STATE OF NORTH CAROLINA DEPARTMENT OF TRANSPORTATION

March 6, 2013

Addendum No. 1

RE: Contract ID C203280 WBS # 10CR.10131.31 Etc. State Funded Cabarrus County 2 Sections Of US-601, 1 Section Of NC-3, 3 Sections Of NC-73 And 13 Sections of Secondary Roads

| STATE | PROJECT NO. | SHEET NO. | TOTAL SHEETS |
|------------------|------------------------------|-----------|--------------|
| N.C. | IOCR.10131,31-IOCR.20131,104 | 5 | 8 |

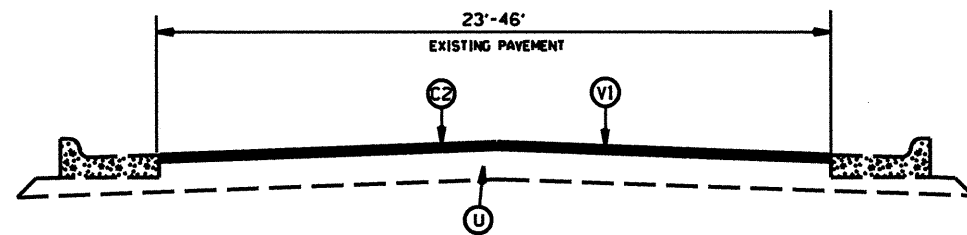
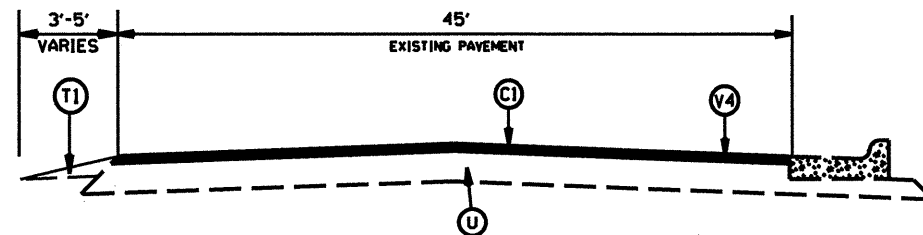
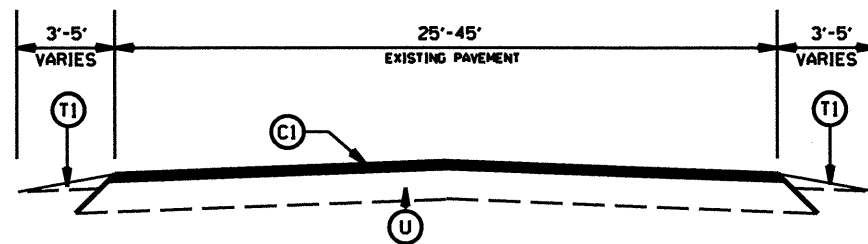
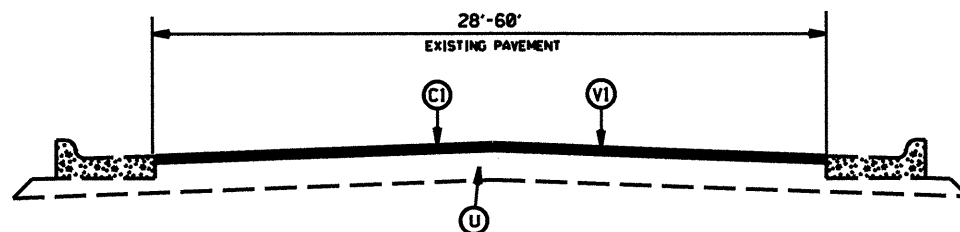
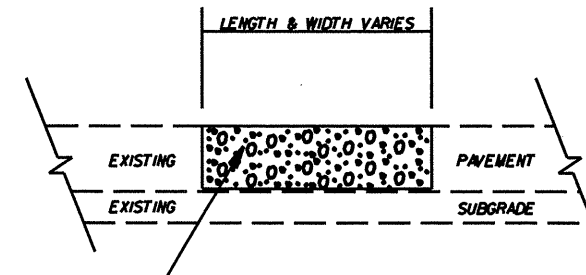
On Sheet Nos. 5 thru 8 the pavement schedule was revised to change to Asphalt Surface Treatment, Mat Coat #6M Stone. Please void Sheet Nos. 5 thru 8 in your plans and staple the revised Sheet Nos. 5 thru 8 thereto.
